Recommendation Report for Planning Permission for Works or Extension to a Dwelling

REF NO: BR/49/18/HH

LOCATION: 11 Elmwood Avenue
Bognor Regis
PO22 8DE

PROPOSAL: Two storey side & single storey rear extensions.

| 11713.06A                          |

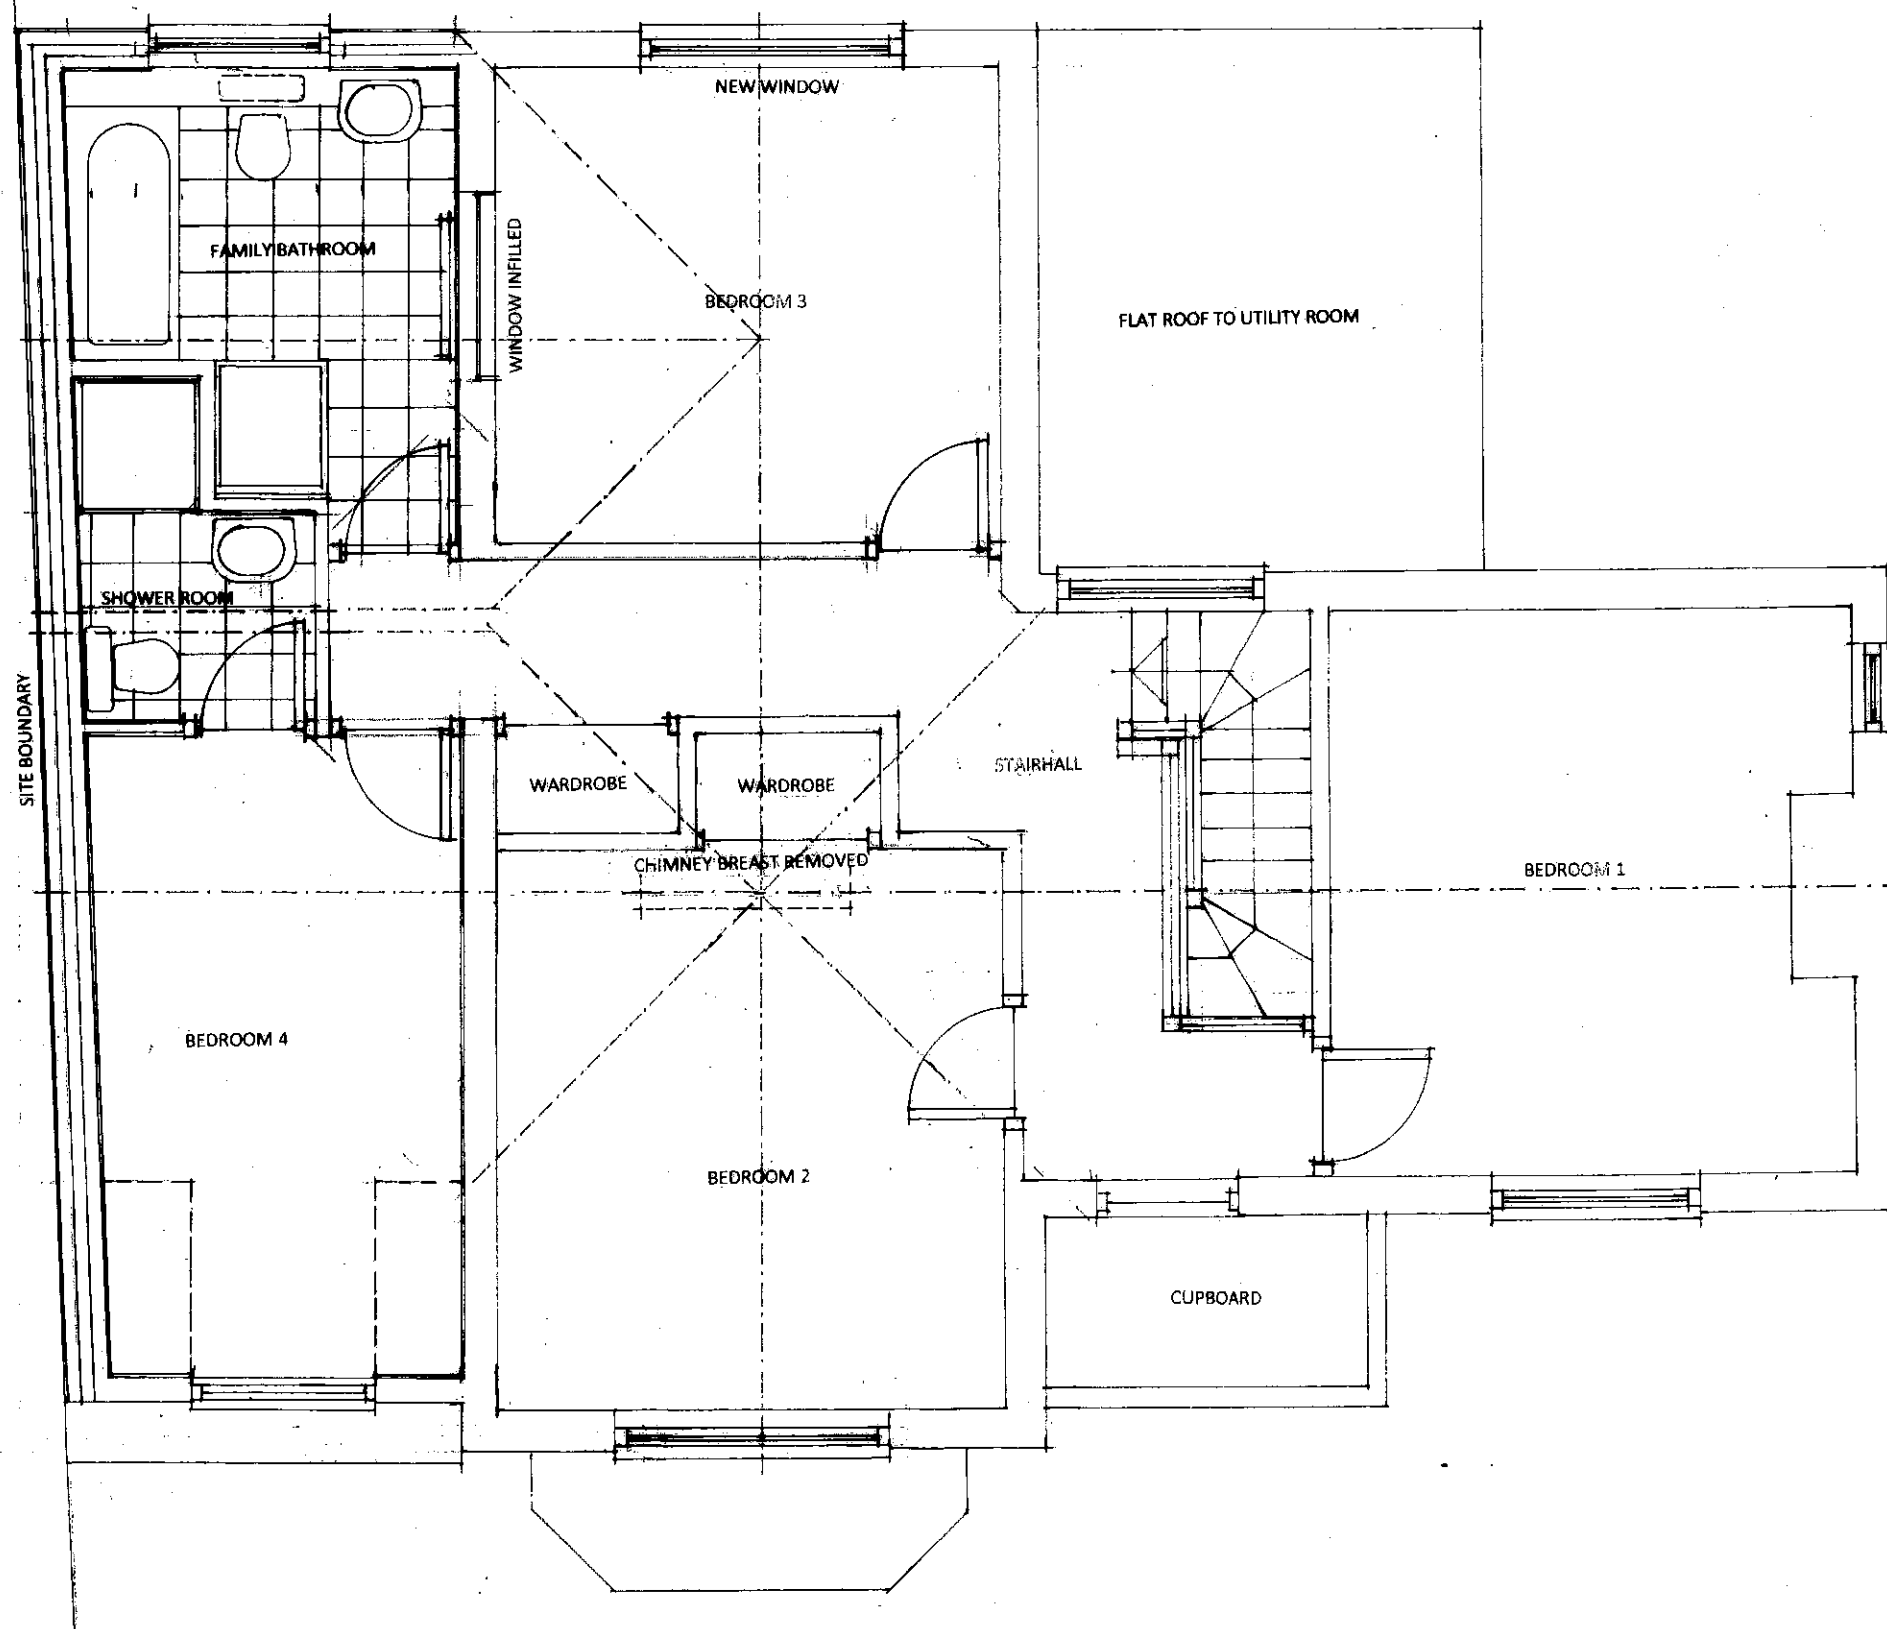
No windows are proposed into the side elevation of the proposed 2 storey side extension. However, 2 windows are proposed into the rear of the resultant dwelling at first floor level. One window would serve a bathroom and the other a bedroom. When the 45 degree approach is applied it is considered that no

materially detrimental overlooking would occur to the primary amenity space immediately to the rear of adjoining property number 9 from the proposed bedroom window, however it is considered that some materially harmful overlooking would occur from the bathroom window. Therefore officers consider an obscure glazing condition re: the bathroom window to be appropriate and one will be imposed on any grant of planning permission.

- 3 The window, serving the bathroom on the west elevation of the building shall at all times be glazed with obscured glass and fixed to be permanently non-opening to a height of 1.7 metres from the floor of the room it serves.

CLIENT
MRS A STENNETT
PROJECT
PROPOSED ALTERATIONS AND EXTENSION
11 ELMWOOD AVENUE
DOGNOR NEW PO22 8DE
DRAWING TITLE
PROPOSED ELEVATIONS
SCALE
1/100 @ A3
REFERENCE
11713.07

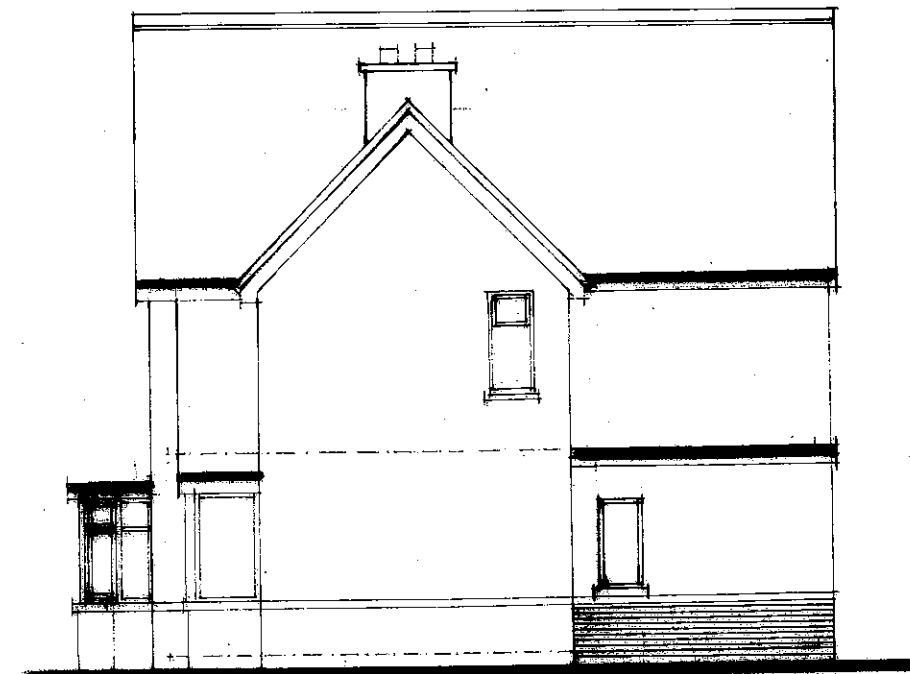
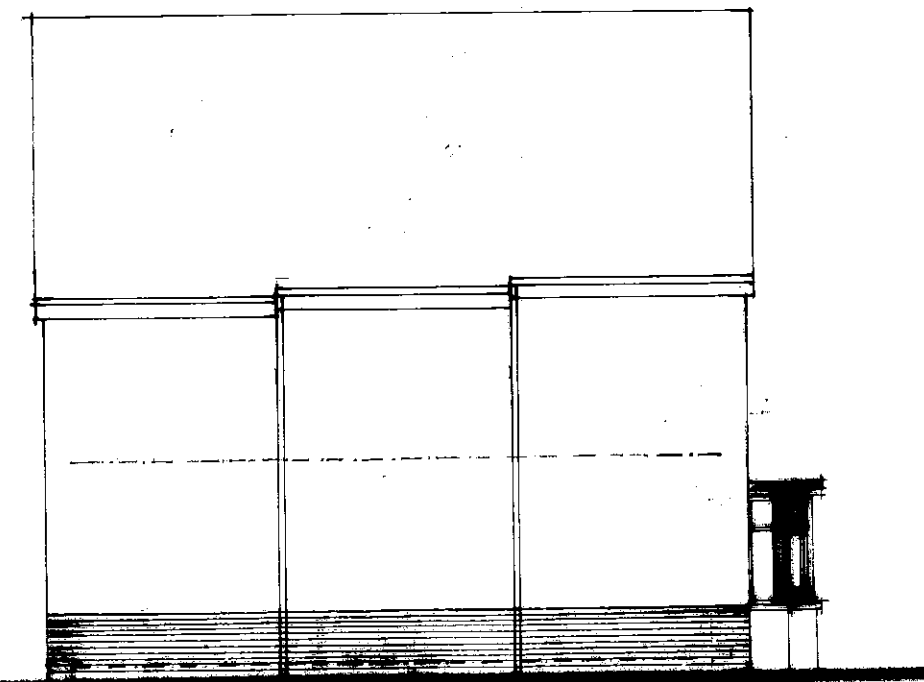
From the Officer's site visit and an assessment of the plans it is noted that the proposed side extension would have the effect of enlarging the front facing gable ended portion of the dwelling up to the common boundary. Additionally the proposal would seek to raise the ridge height of the host dwelling by approximately 1.3 metres. While the proposed side extension would lead to the creation of a larger dwelling it would seek to maintain the style of the existing dwelling, only enlarged.
